Application number: 2025/90642	
What is the application for?:	Variation of condition 2 (plans) on previous permission 2024/92979 for erection
Address of the site or building:	31, Skelton Crescent, Crosland Moor, Huddersfield, HD4 5PN
Postcode:

3 (West) Rear Elevation as Proposed
1 : 50

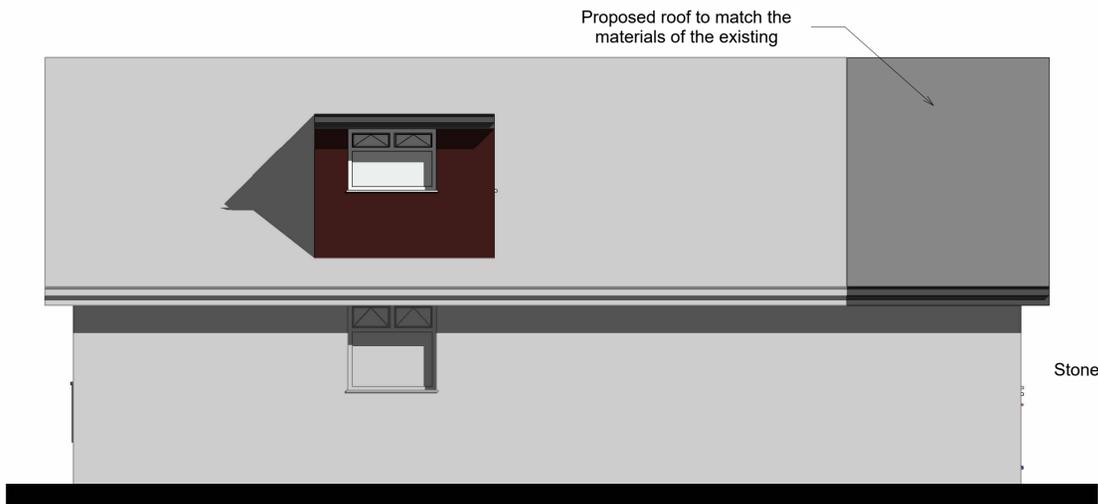
Type of comment: An objection	
Do you wish your comments to be published on the website anonymously?	Yes
West elevation bathroom windows will look straight into my main bedroom window of my bungalow
